ARBORICULTURIST'S COMMENTS

From: Ian Brewster
Sent: 16 August 2013 14:38
To: Janice Chapman
Subject: RE: AW/134/13/T Garth Cottage, 44 Fish Lane, Aldwick

4 = HOLLY TREE (IN EXCESS OF 30' TALL + SPREAD)
AROUND 30'

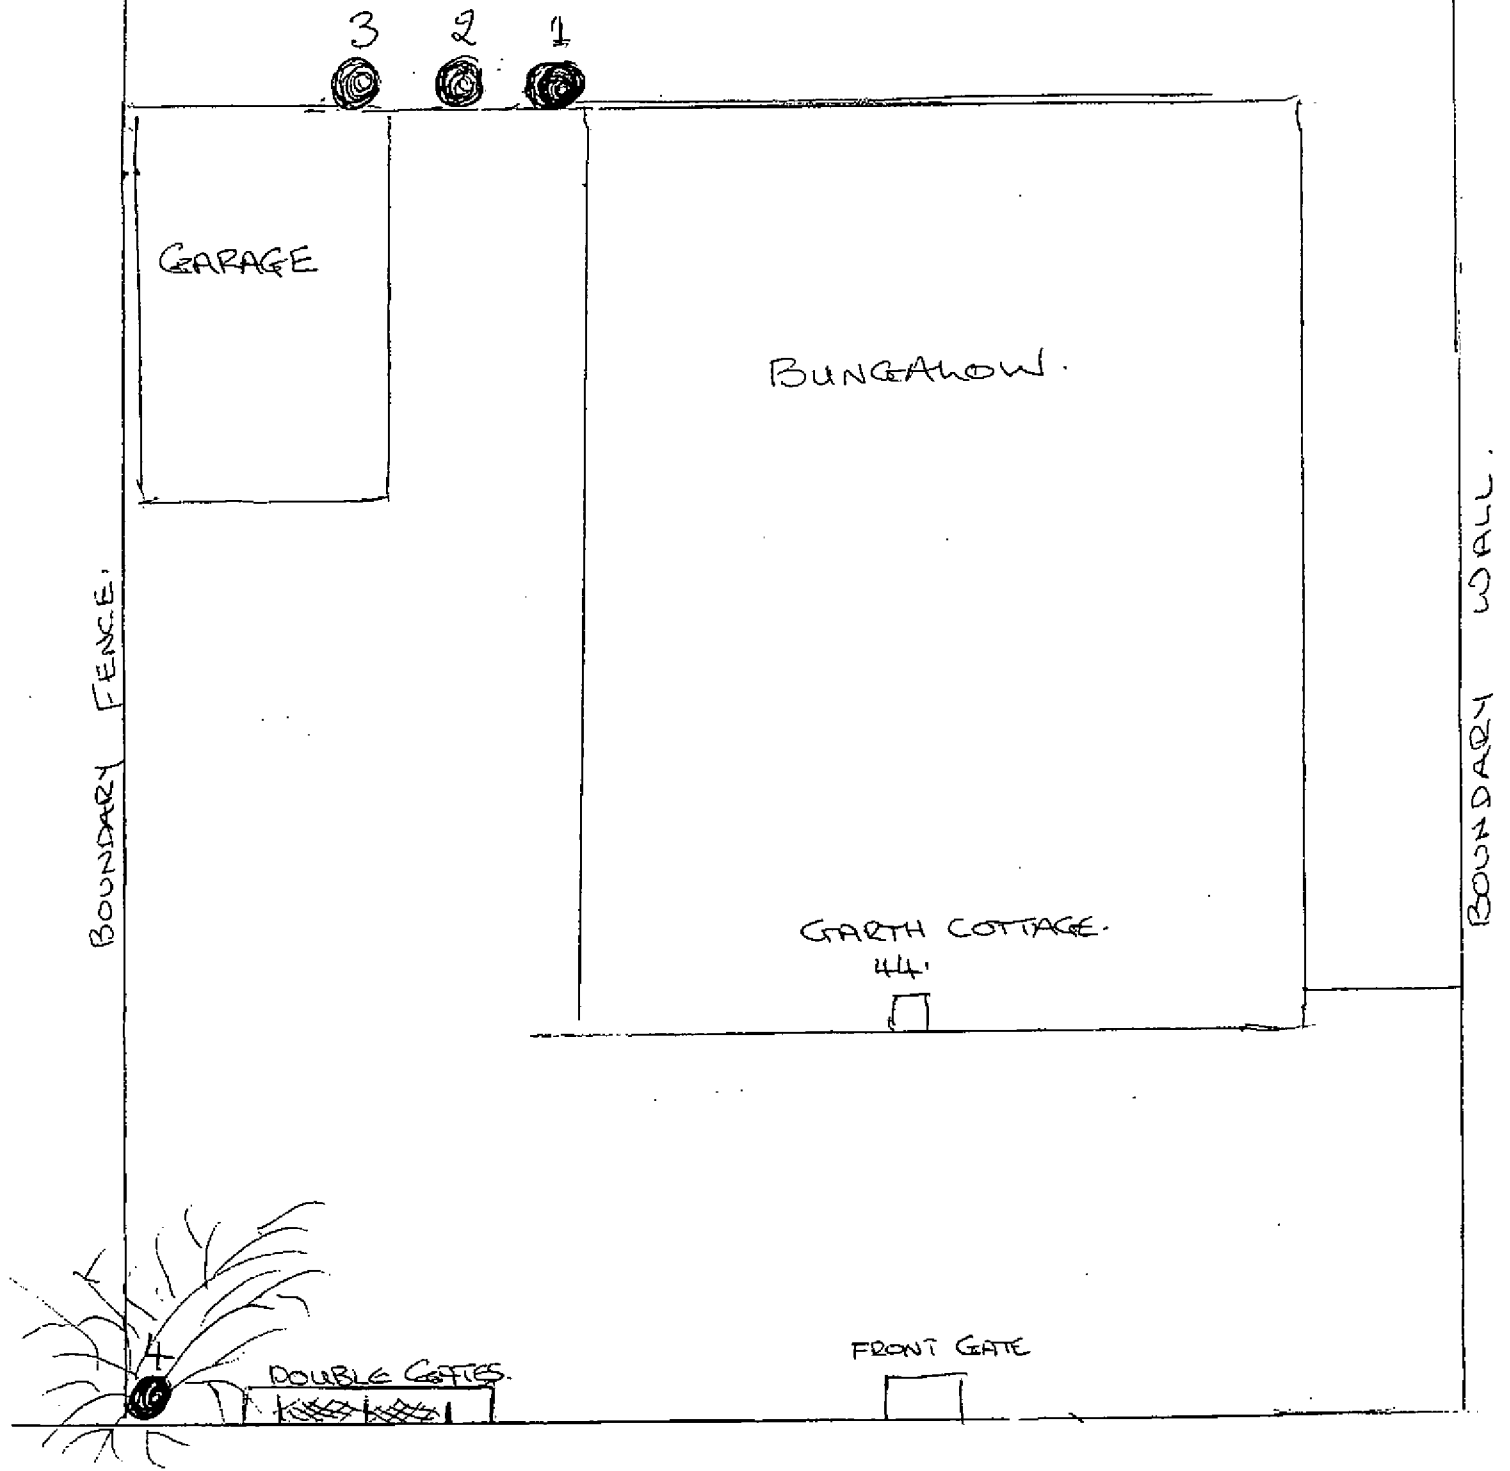
The Holly is a significant visual amenity as it is clearly visible from the highway. The reason provided for reducing the crown by 2-3m to remove overhang from a neighbour's property is not justified as this would diminish the visual amenity of the tree. There may be scope to have the lower crown lifted to provide clear unobstructed access for pedestrians. The application for work to the Holly should therefore not be granted consent.

I do not regard the three Monterey Cypress trees as being protected by the Area Order of 1958. It is reasonable to assume that they would have been planted after this date and are therefore younger than the order. They are also not worthy of a TPO having lost approximately 50% of the lower crown due to excessive crown lifting.
